CITY OF ALBUQUERQUE

July 1, 2024

**Re: Opus Transport Apartments
Traffic Impact Study (M15D023H)**
Engineer's Stamp DRAFT
Via email jroberts@tierrawestllc.com

The subject Traffic Impact Study (Study) draft received on June 17, 2024, has been reviewed by the City of Albuquerque Planning Development Transportation Section. The City has the following comments to be addressed.

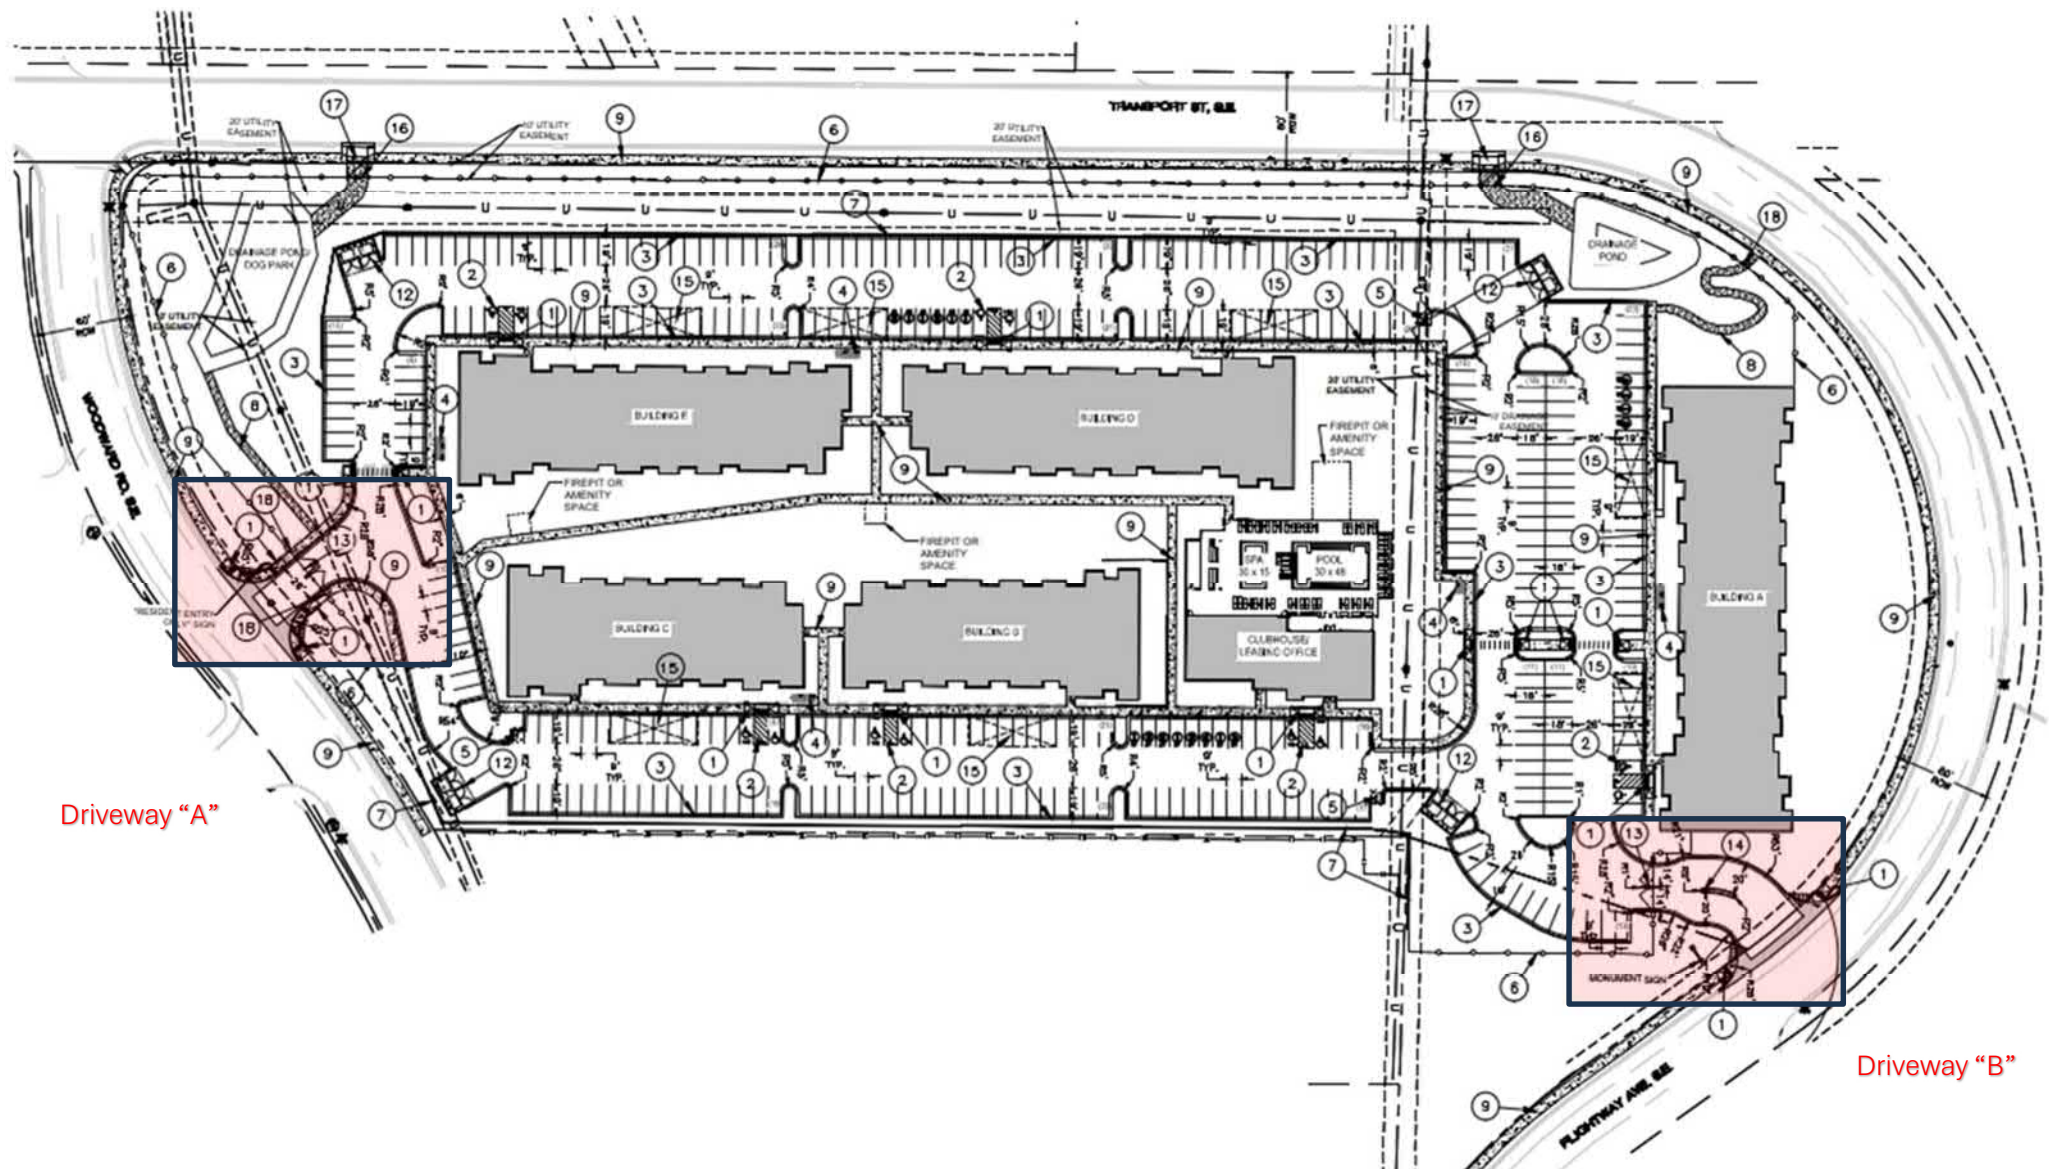
2. Woodward Rd and University Blvd:
 - i. Eastbound Woodward to northbound University has an LOS of F in the 2025 and 2035 Conditions, with the 2035 condition having a longer delay (104 vs 72 seconds) than in 2025 and appears to meet the signal warrants. The City agrees the signal would be too close to the signal at Sunport Blvd.

- ii. With over 840 vehicles southbound on University and 183 (2025 Build Volume) cars turning right from Woodward Rd onto University Blvd and no striped right-turn lane, why is there no delay for cars turning right onto southbound University Blvd?

- iii. Please extrapolate/provide details on the recommendation "Striping is recommended along the entire roadway to delineate lanes...".
 - iv. I do not think that accounting for autonomous vehicles becoming more prevalent in the future can be used to assume a delay will be reduced.
